Application No: WA/5/22/PL
Site Address: Morelands Arundel Road Fontwell BN18 0SB
Description of works: Demolition of 1 No dwelling & erection of 5 No dwellings with associated car parking and access. This site is in CIL Zone 2 and is CIL Liable as new dwellings.

Thank you for your internet representation made on 7th February 2022 which has been recorded as an objection with the comments as follows:

TITLE
**Building B -
Elevations**

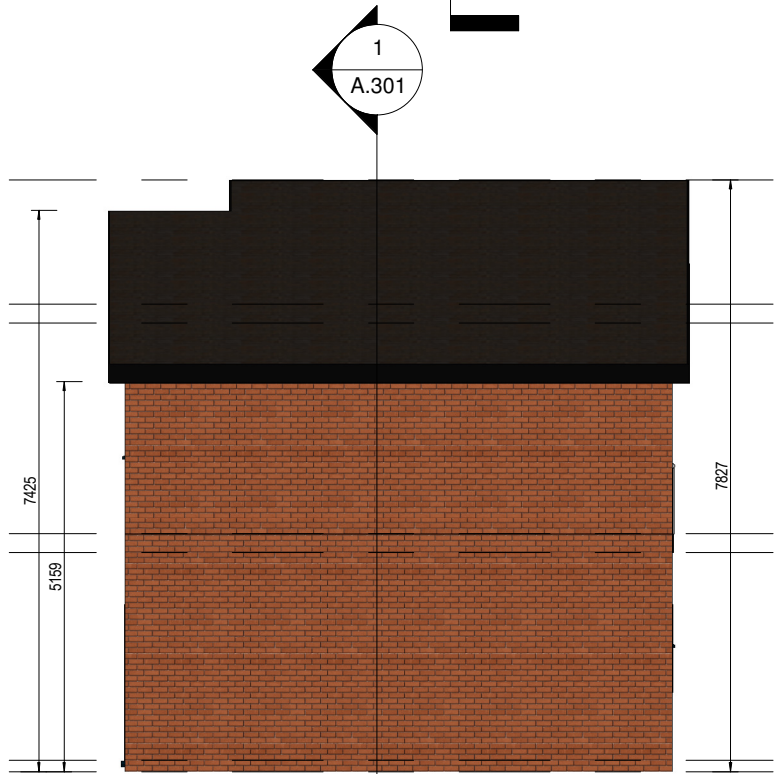
I feel very strongly that this proposed type of house design is not in keeping with the local Sussex style of property they are London town houses !
The amount of glass and high up balconies over looking our property its not fair on the locals.
